DRB Application No.: 08DRB-70045 Project # 1007043  
 Project Name: TOWN OF ATRISCO GRANT UNIT NE  
 Agent: PETE DASKALOS & JOHN GALLEGOS Phone No.:

**CITY OF ALBUQUERQUE  
PLANNING DEPARTMENT  
January 30, 2008  
DRB Comments**

**PROJECT # 1007043                      APPLICATION # 08-70045**

**RE: Lot A-35-B, Town of Atrisco Grant, NE Unit**

**PLAT OF
LOTS A-35-B-1 AND A-35-B-2
TOWN OF ATRISCO GRANT, NE UNIT
PROJ. SEC. 2, T.10N., R.2E., N.M.P.M.
ALBUQUERQUE, NEW MEXICO
JANUARY 2008**

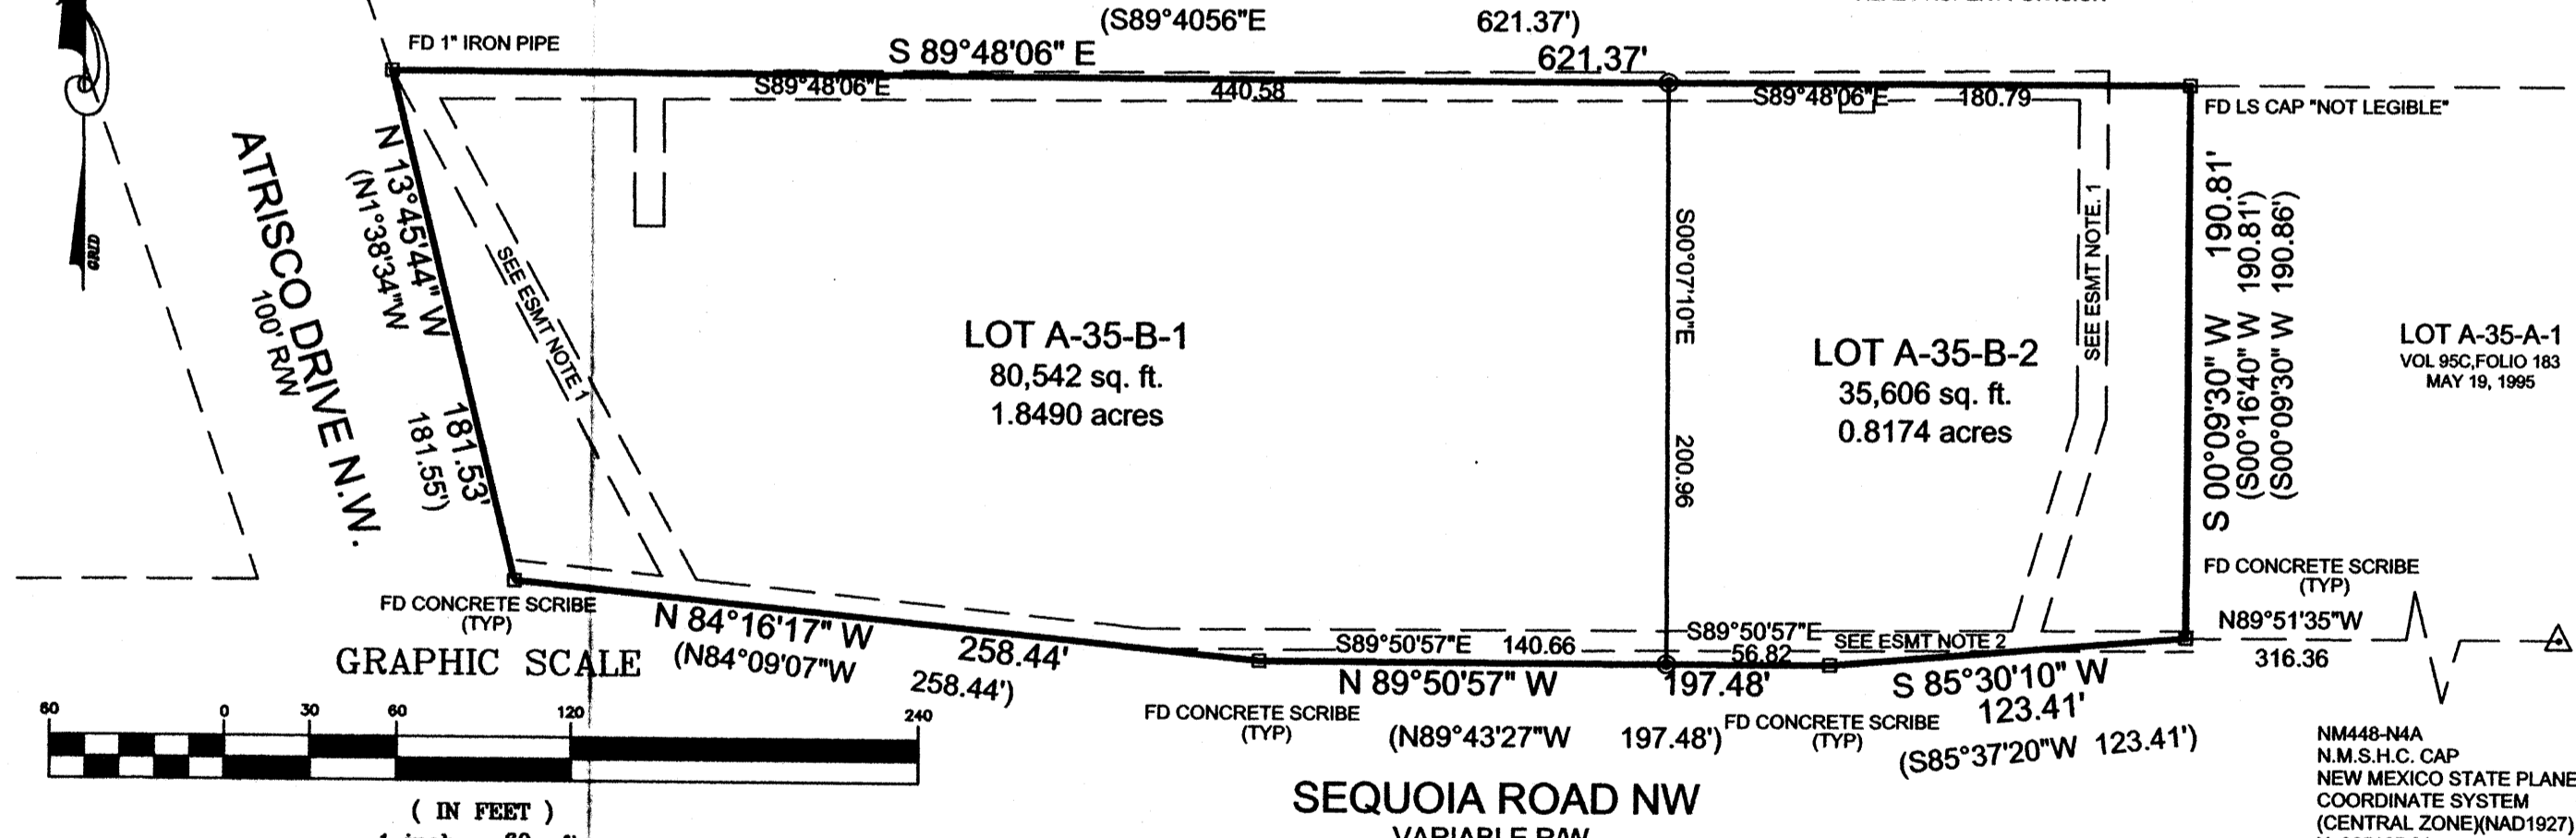
PLANNING (Last to sign): - check for reciprocal easement

16. ~~Project# 1007043~~  
08DRB-70045 MINOR - PRELIMINARY/  
FINAL PLAT APPROVAL
- PETE DASKALOS & JOHN GALLEGOS request(s) the above action(s) for all or a portion of Lot(s) A35-B-1 & A35-B-2, **TOWN OF ATRISCO GRANT Unit(s) NE**, zoned SU-1 FOR C-1 & O-1 USES, located on SEQUIOA NW BETWEEN ATRISCO NW AND COORS NW containing approximately 2.6664 acre(s). (G-11) **THE PRELIMINARY/FINAL AT WAS APPROVED WITH FINAL SIGN OFF DELEGATED TO PLANNING FOR RECIPROCAL ACCESS PARKING AND DRAINAGE EASMENT, AND TO PLANNING FOR INDICATION OF WIDTH AT NARROWEST POINT, 25 FT RADIUS AT INTERSECTION OF ATRISCO AND SEQUOIA, WIDTH OF RIGHT-OF-WAY, AND EXHIBIT SHOWING SIDEWALK AND DISTANCE OF FACE OF CURB TO PROPERTY LINE.**

A Subdivision Note consistent with Section 14-14-4-7 (B) of the Subdivision Ordinance regarding solar collectors is required; the language needs to be specific to this type of request, i.e. replace the words "REQUESTED FINAL ACTION" from the ordinance with the words "THIS PLAT" at the beginning of the note, and delete the words "OR SITE DEVELOPMENT PLAN FOR SUBDIVISION" at the end of the note.

Reciprocal Easements need to be called out on plat for access, parking, drainage, etc. to serve both proposed lots.
